Ref: 24010A-DE-EWC04
26th June 2025

**2-4 Burleigh Street & 20-24 Railway Parade, Burwood, NSW
Response to Submission comments**

The wind tunnel model study of the environmental wind conditions was completed in June 2024 with the wind tunnel model constructed to drawings supplied by NSW Housing Corporation Pty Ltd (PTI Architecture) and received 22nd May, 2024. The findings of the study were reported in MEL Consultants Report 24010-WT-ENV01, dated 17th December, 2024.

The Department of Planning, Housing and Infrastructure has issued a Request for Additional Information letter, dated 20th June 2025, requesting clarification of the following wind related queries in relation to the aforementioned MEL Consultants wind report :

DRAWING TITLE:
**LEVELS 3-8 FLOOR PLAN-
RESIDENTIAL**

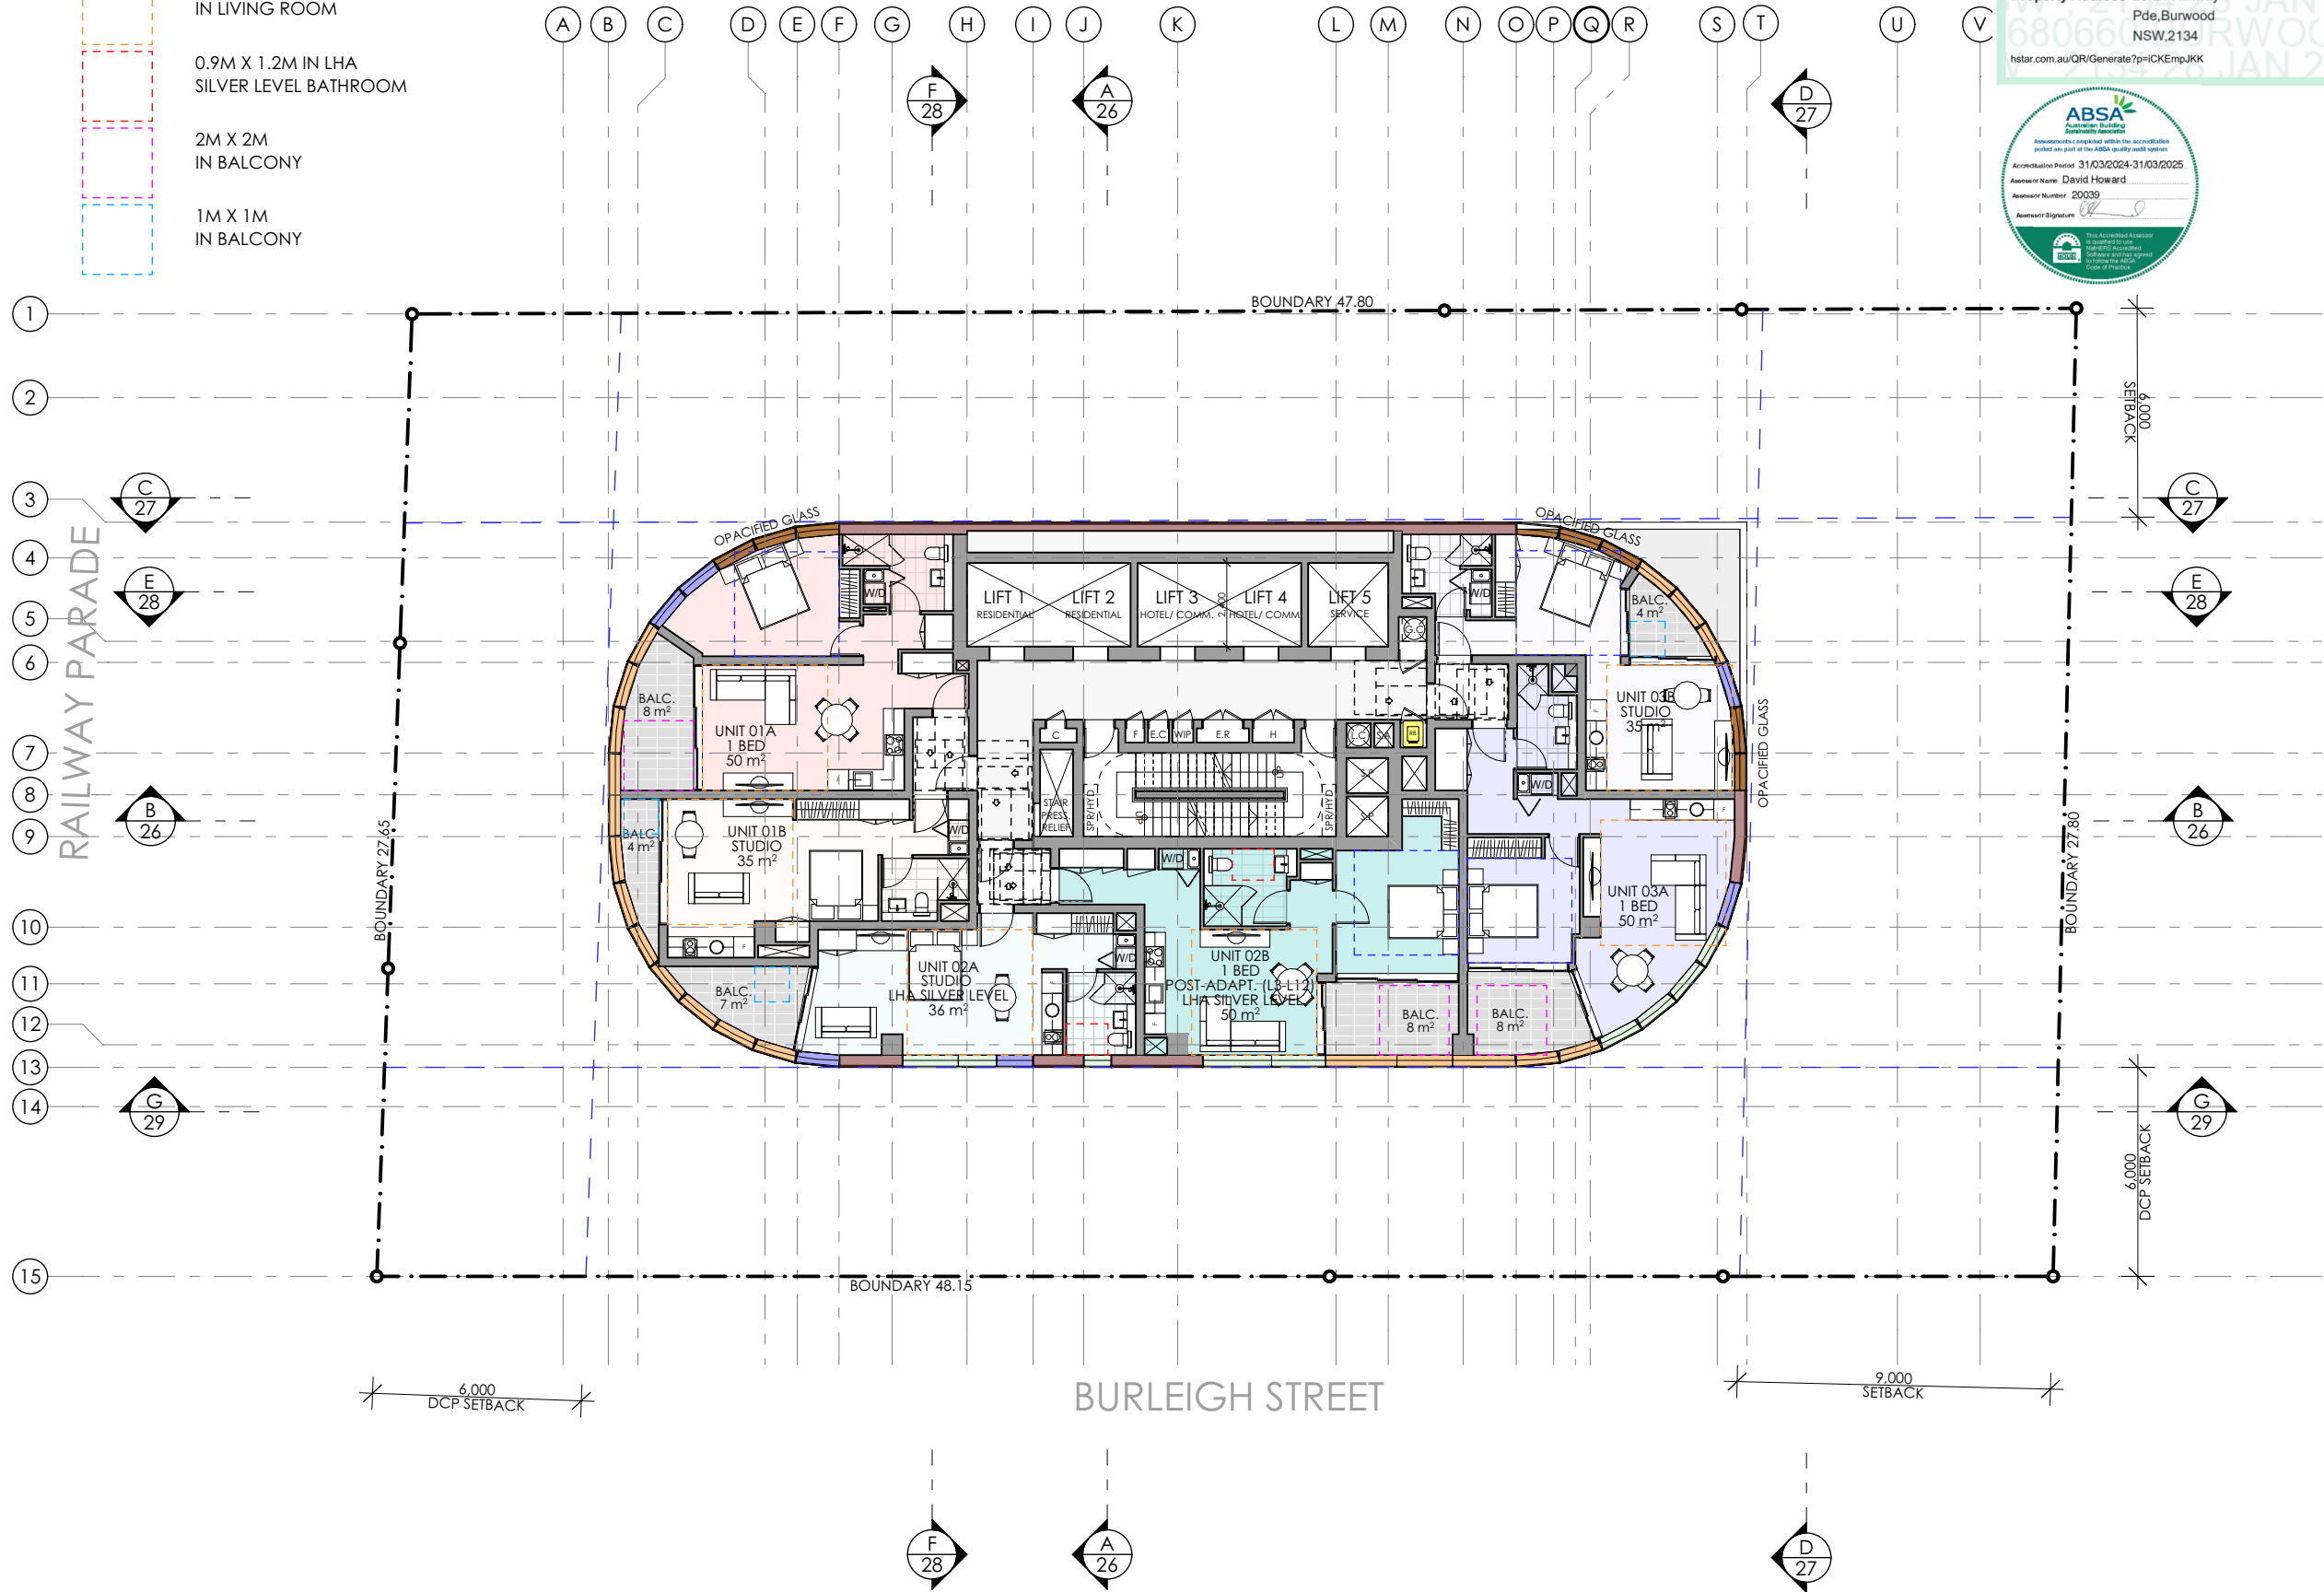
b. Provide an updated PWEA which considers and demonstrates the proposal will achieve acceptable safety and comfort levels of the apartment balconies.

The private apartment balconies shown on levels 3 – 18 have openings on only one aspect, with walls and/or privacy screens separating adjacent balconies. Such balcony types typically achieve good levels of wind comfort and would be expected to achieve a minimum of standing comfort criterion, with the sitting comfort criterion likely to be achieved.

LEVEL 36 FLOOR PLAN- HOTEL
FACILITIES

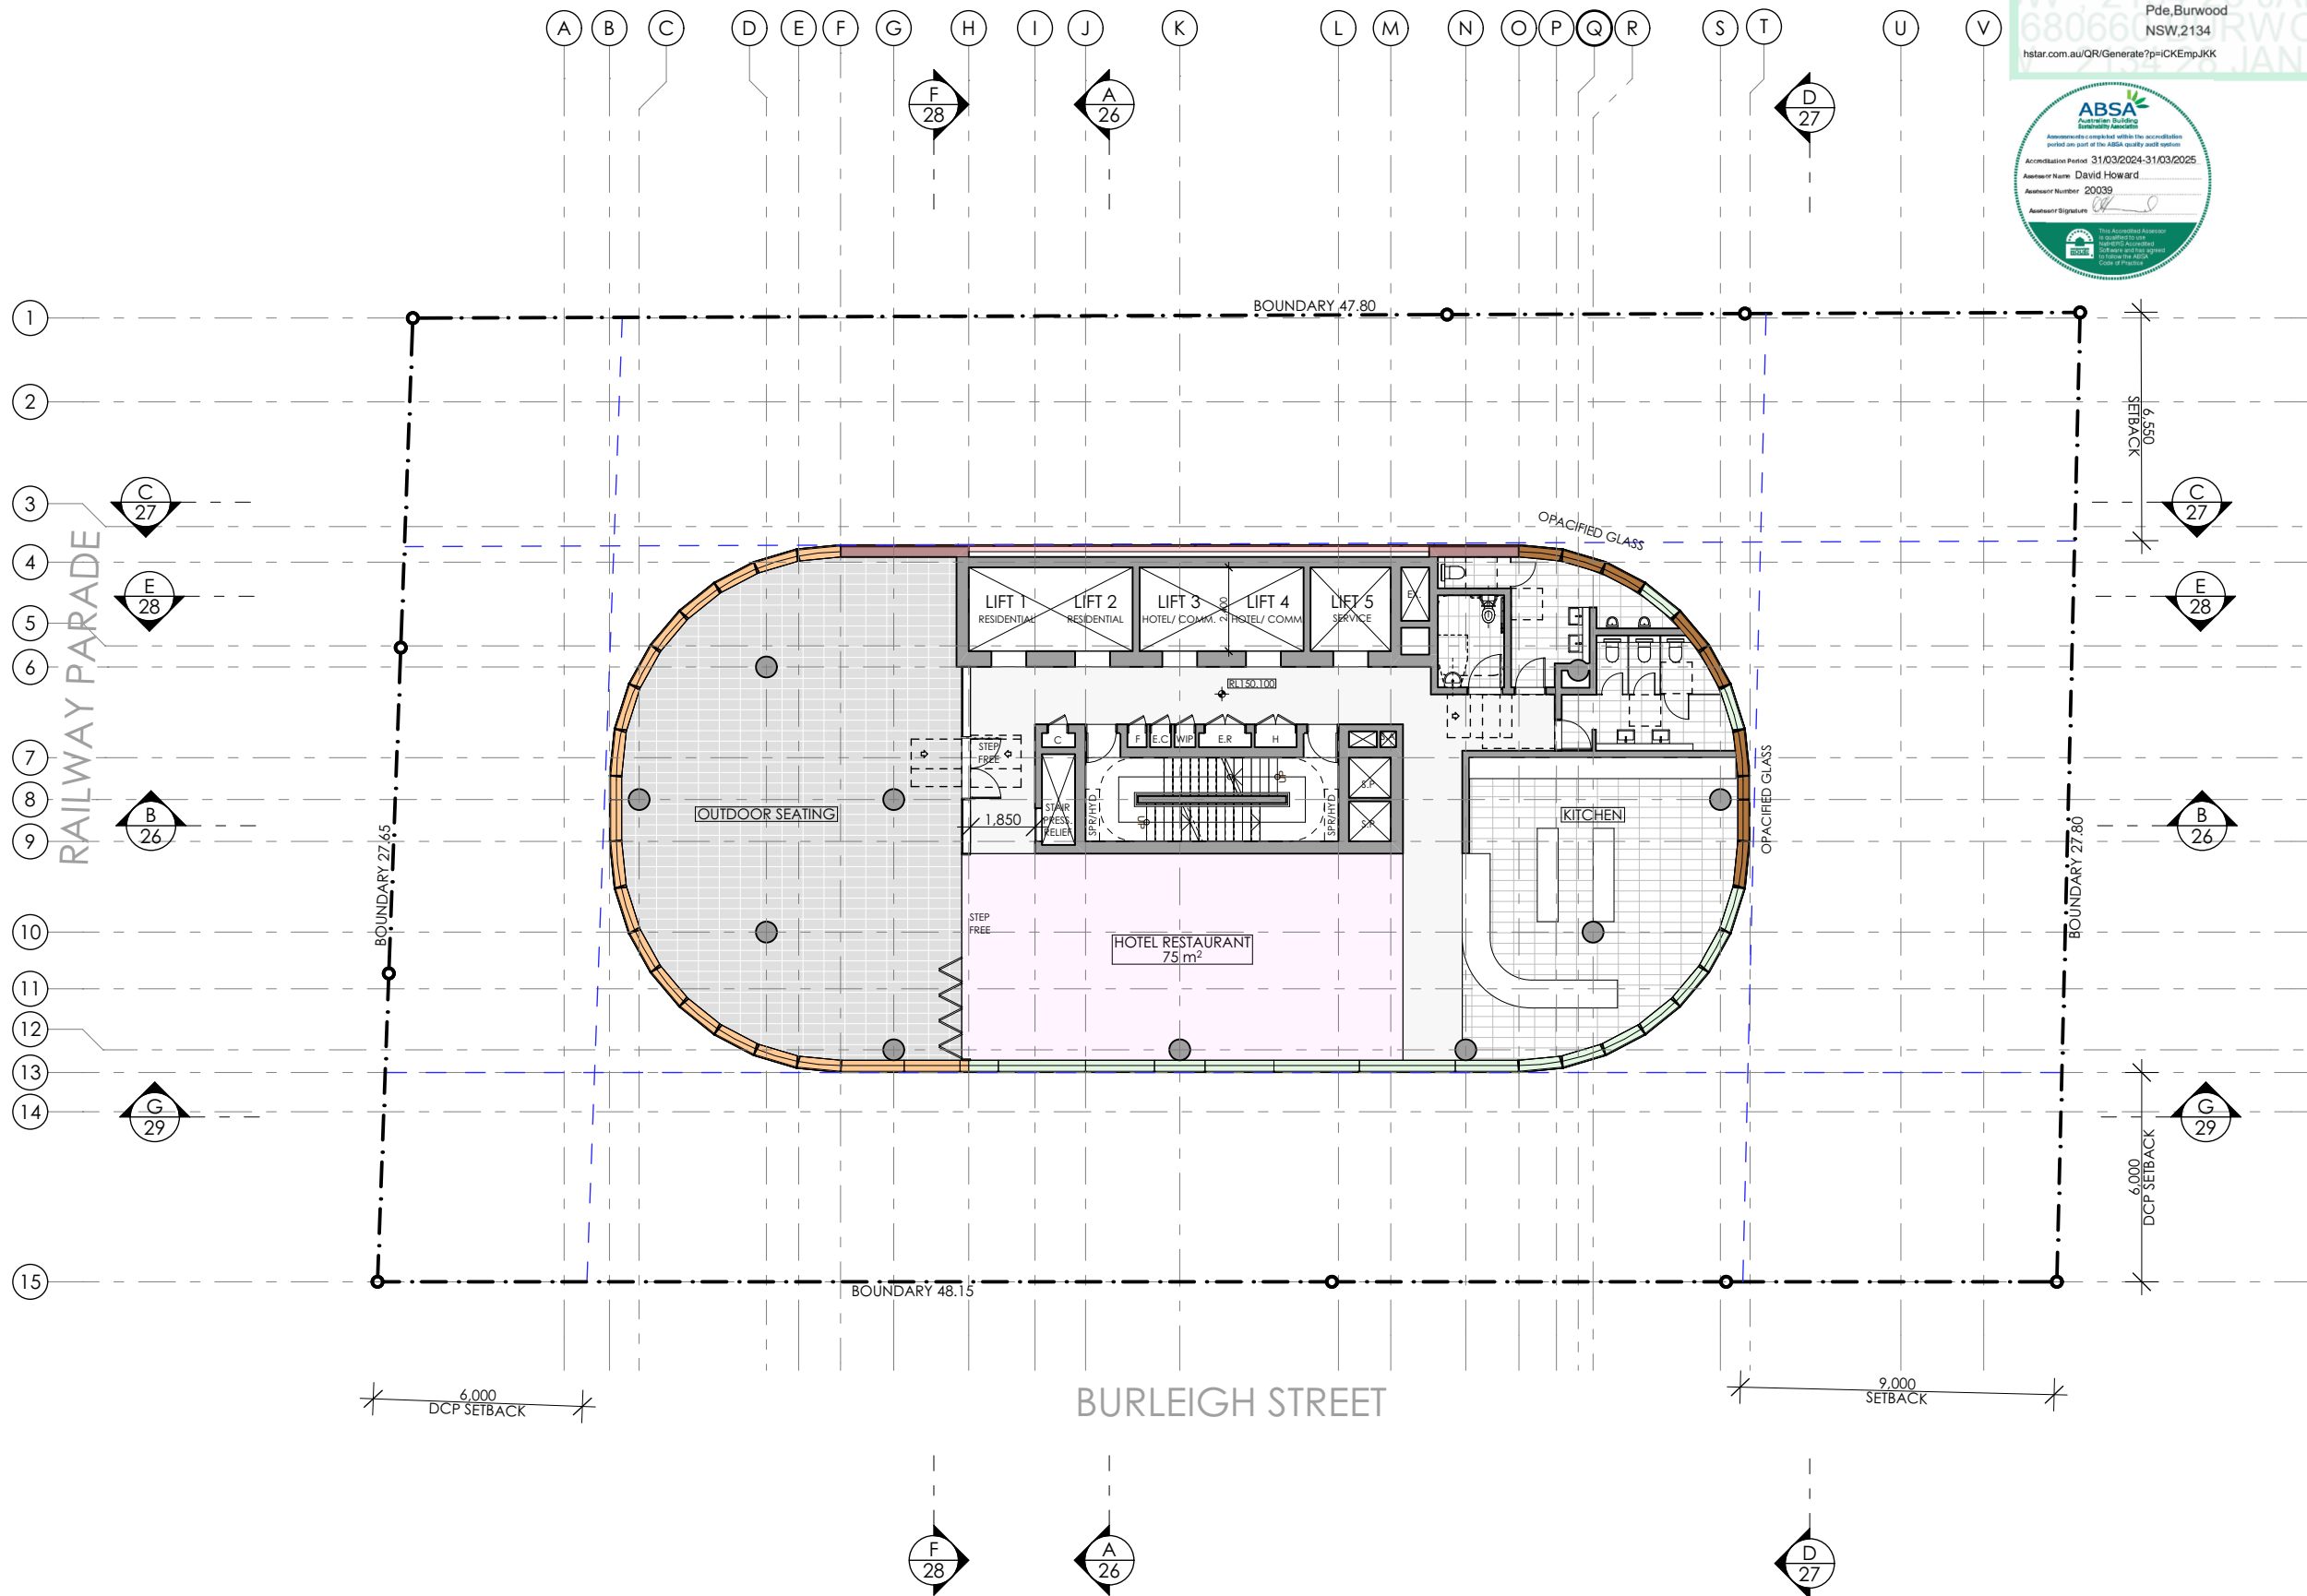
- a. *The Pedestrian Wind Environment Assessment (Appendix 25) (PWEA) indicates external residential COS areas and hotel/commercial external areas at levels 1, 2 and 36 meet standing comfort criteria levels. It is noted that most of these areas will include uses requiring people be seated. Provide further plans/details and mitigation measures, as needed, to demonstrate that the wind conditions in these areas will provide comfortable conditions for the intended use of the spaces.*

Similarly, increasing the balustrade height to 1.6m on the northern half of the communal areas of Level 36 (i.e. from east through north to west aspects) would be expected to improve the wind conditions in this area to achieve the sitting comfort criterion.
